Letter No: **A1/13707/92**

Sub: MMDA - Planning permission - Construction of
residential building in Plot No:2 at S.No:571/1pt
of Uzur village - Approved - Reg.

PROPOSED ADDITIONS TO THE EXISTING GROUND + 1ST FLOOR BUILDING IN PLOT NO. 10, P.O. 1613, PADMANABHA NAGAR 5TH STREET, ADYAR MS-20, S.No. 571/1 PART, T.S. No. 13 & 14 BLOCK 21 OF URUR VILLAGE

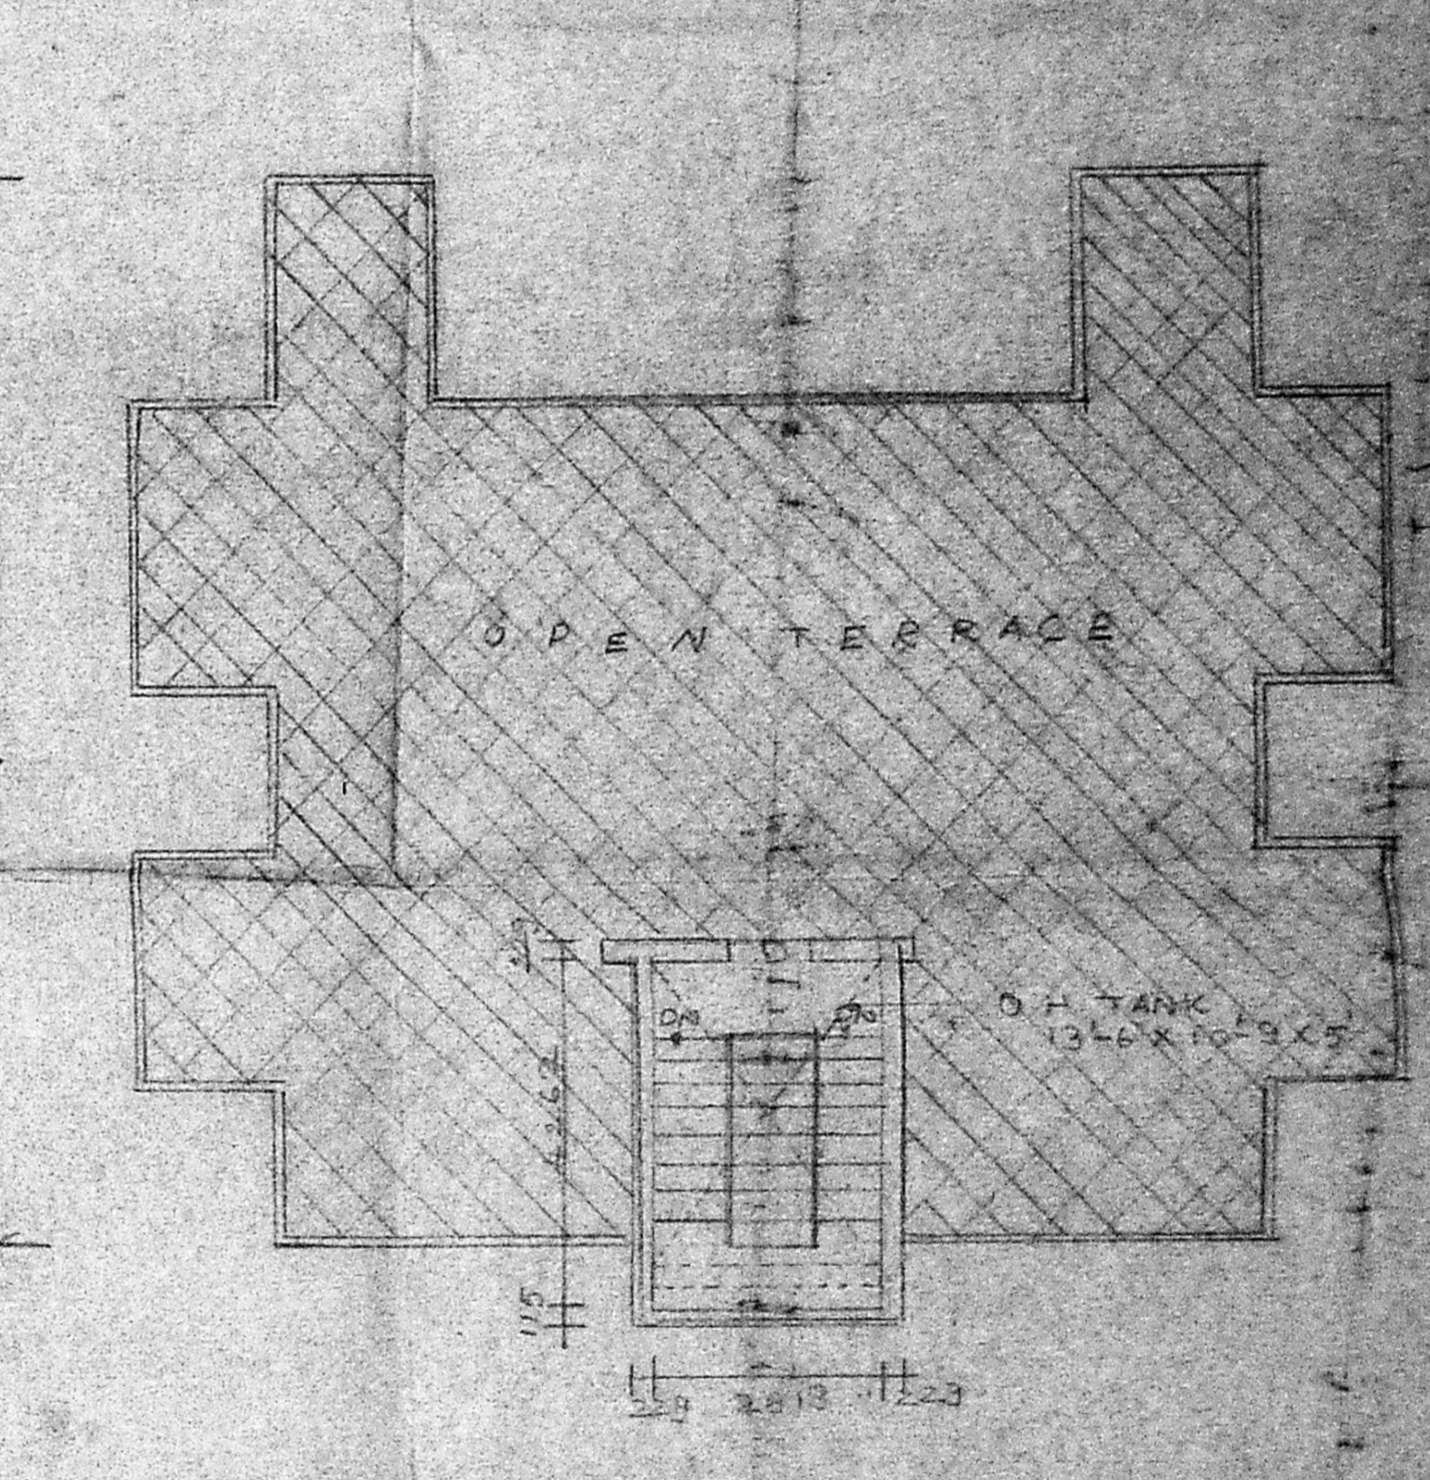
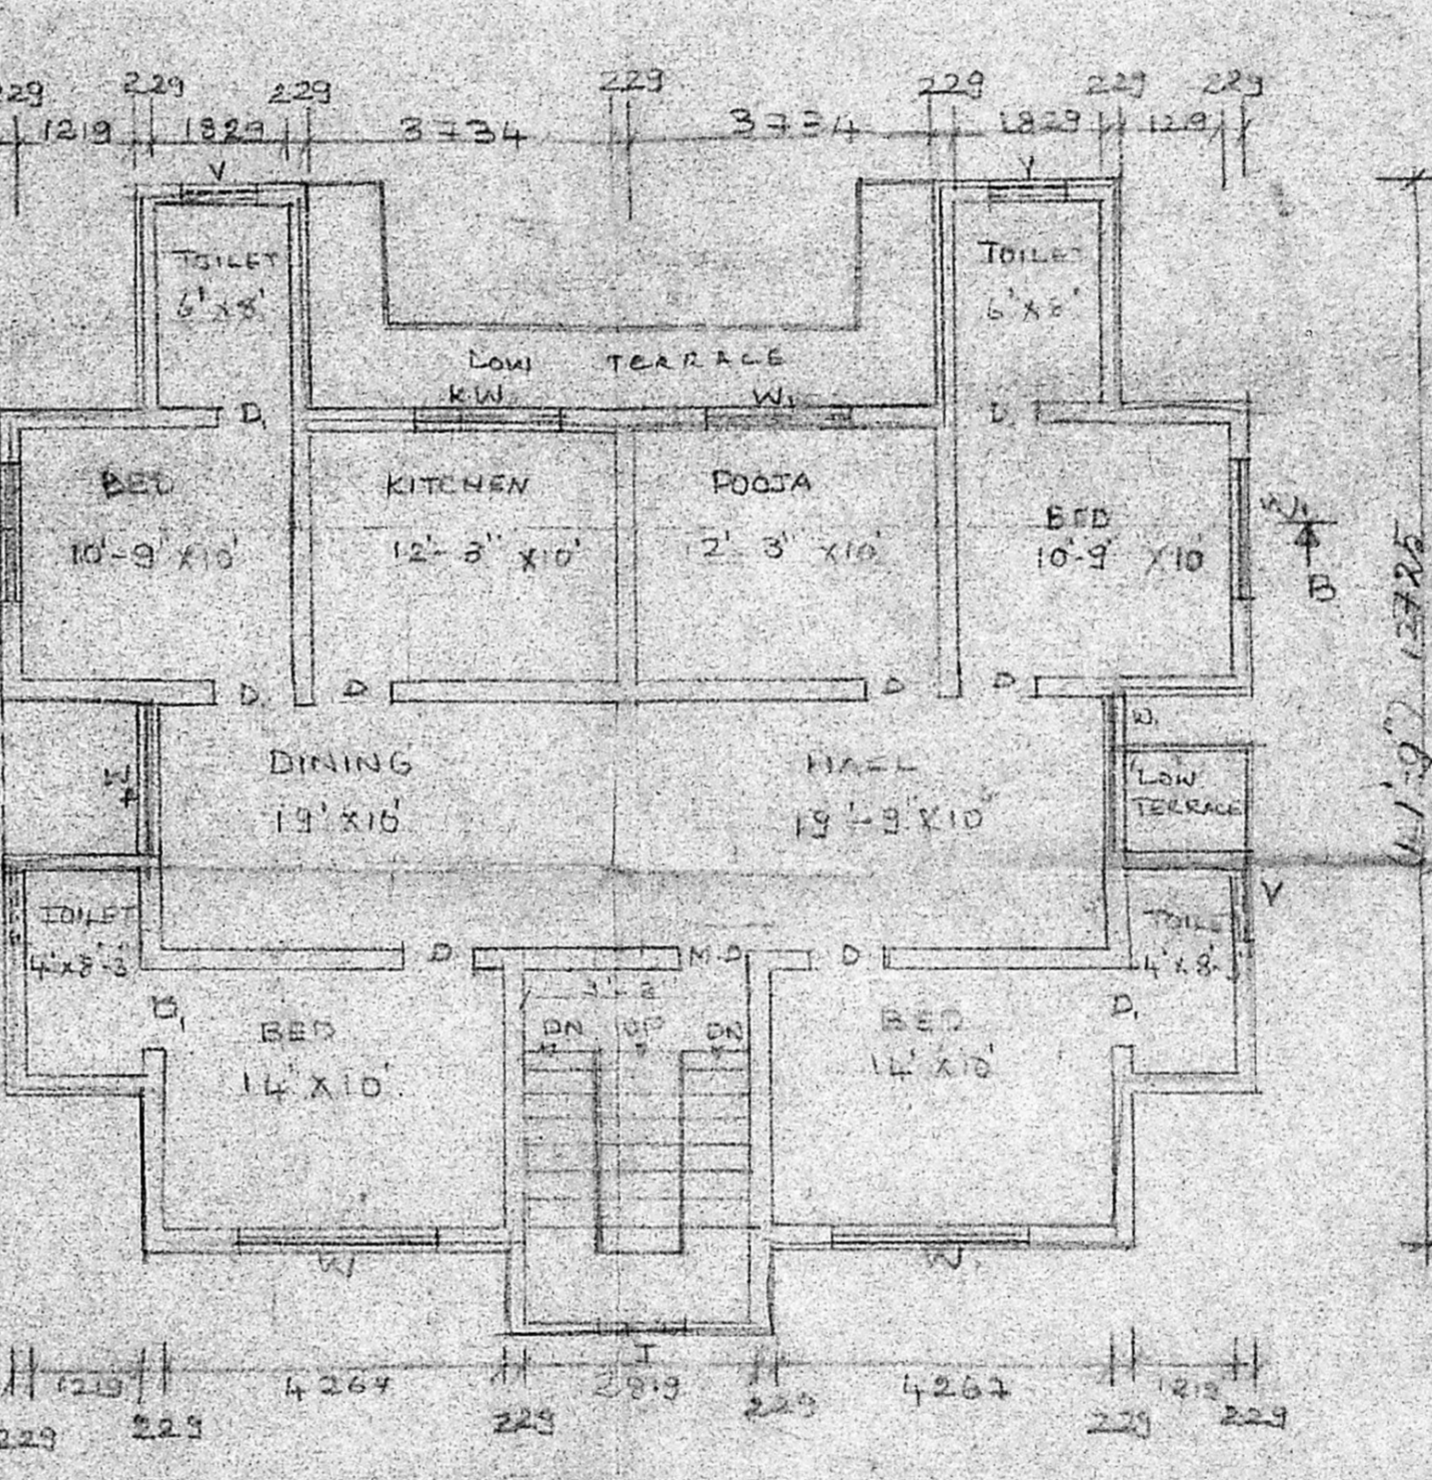
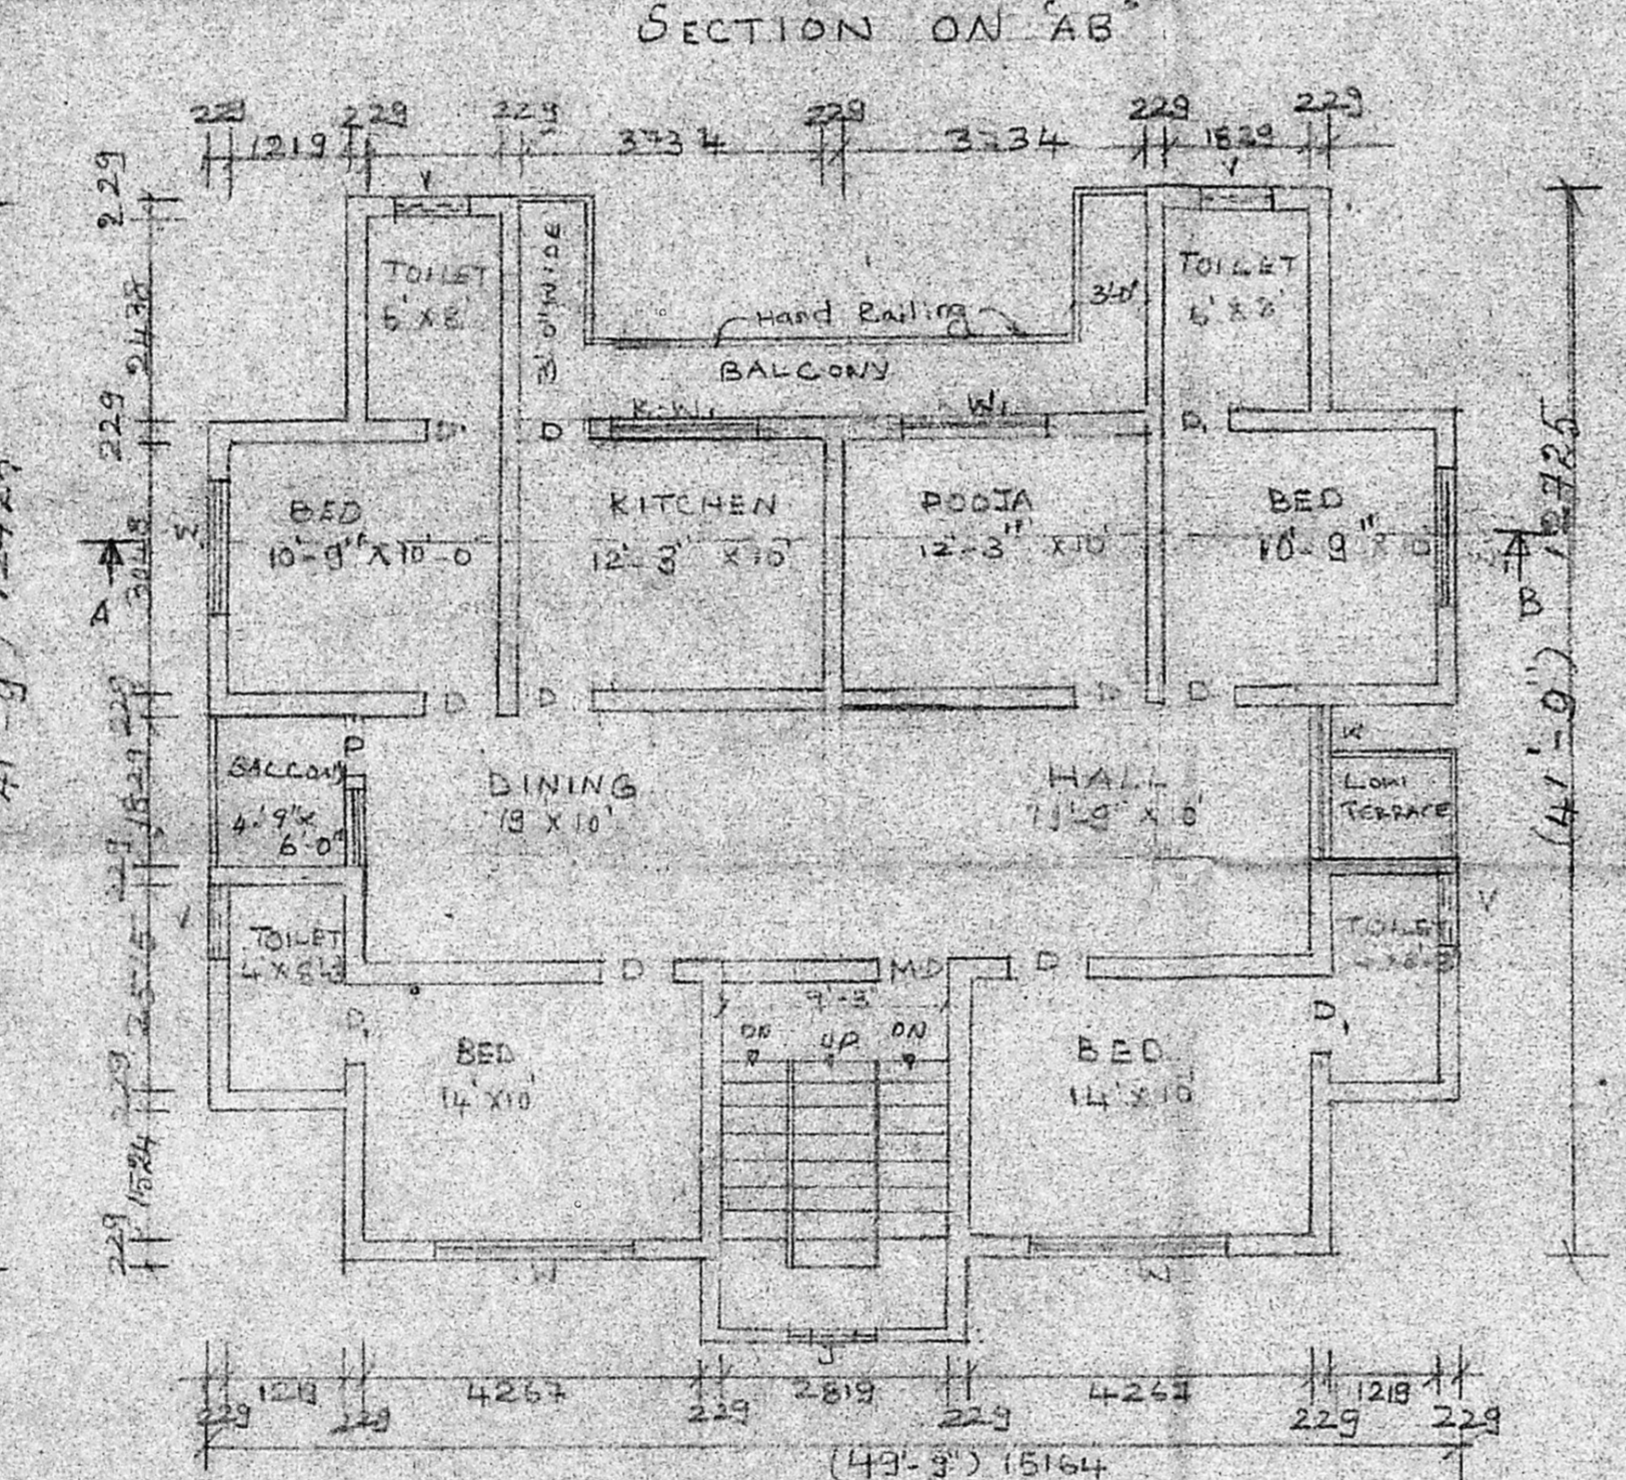
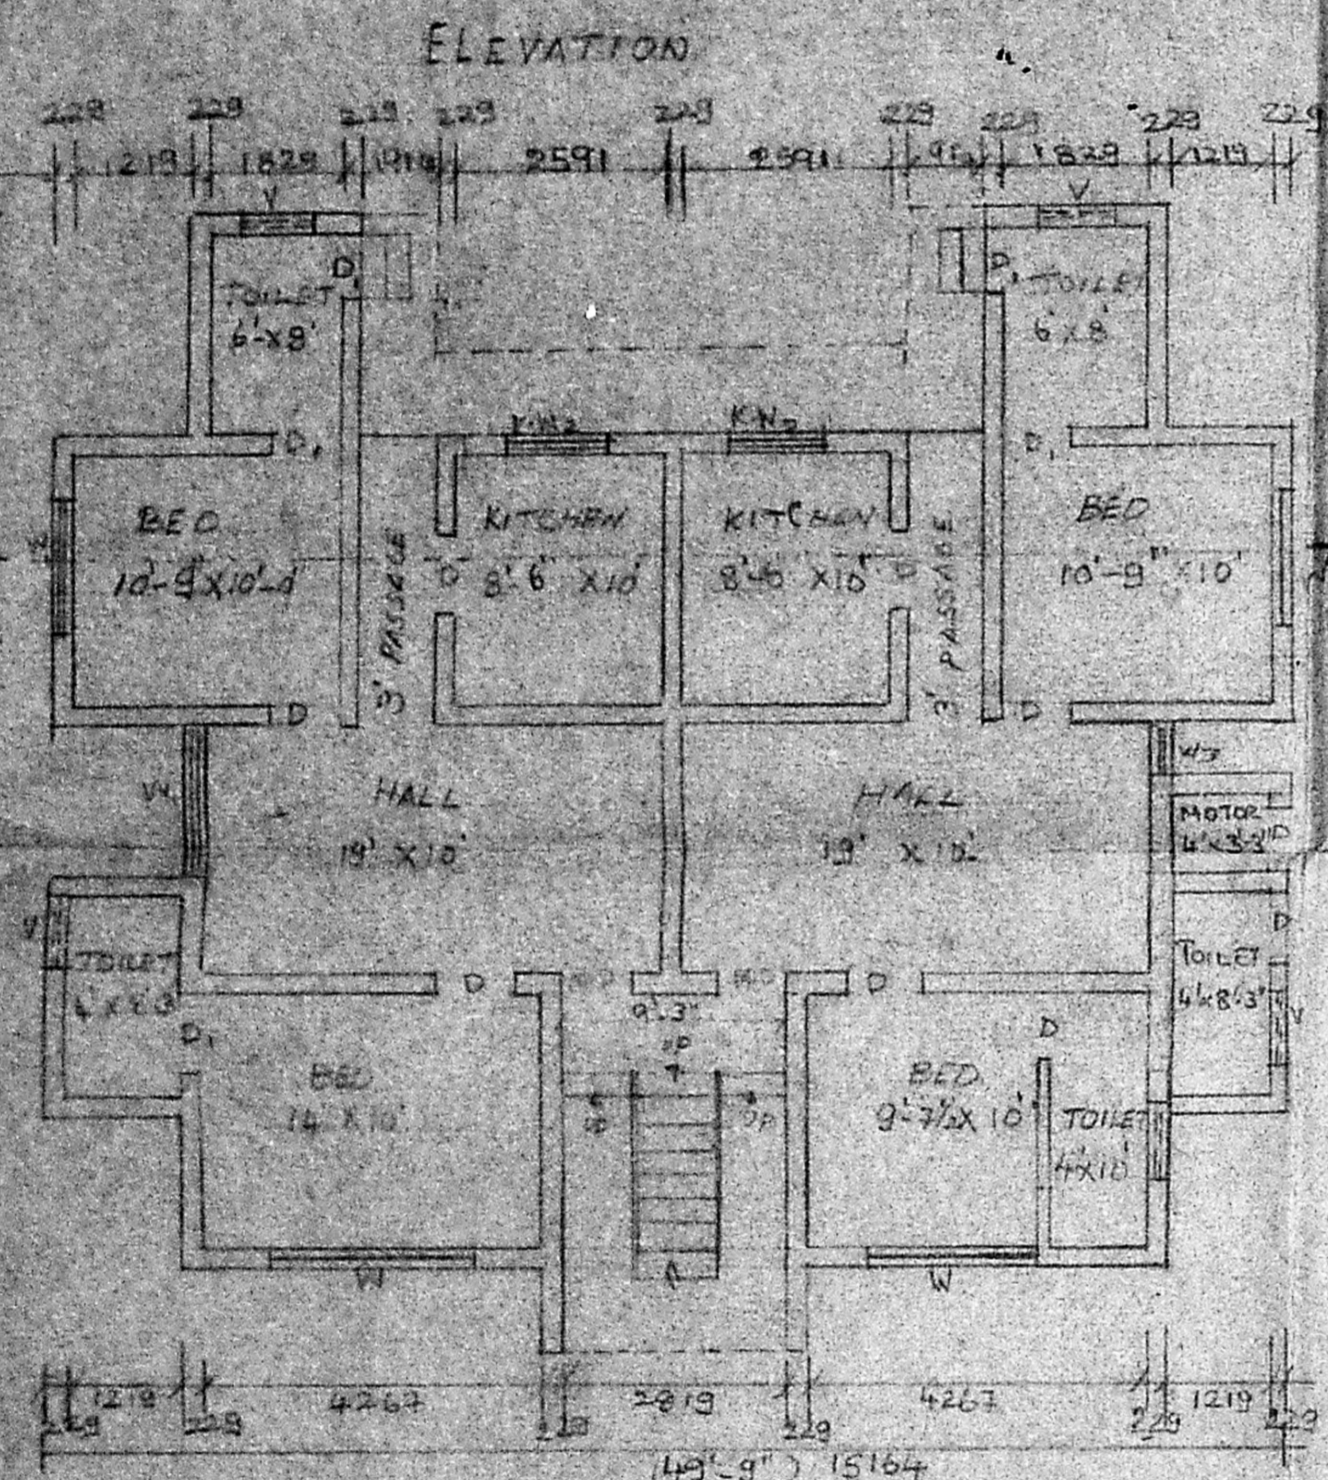
* Also you are requested to demolish the existing lumber
room and submit the five copies of revised plan as on
site condition i.e., without showing the existing
lumber room.
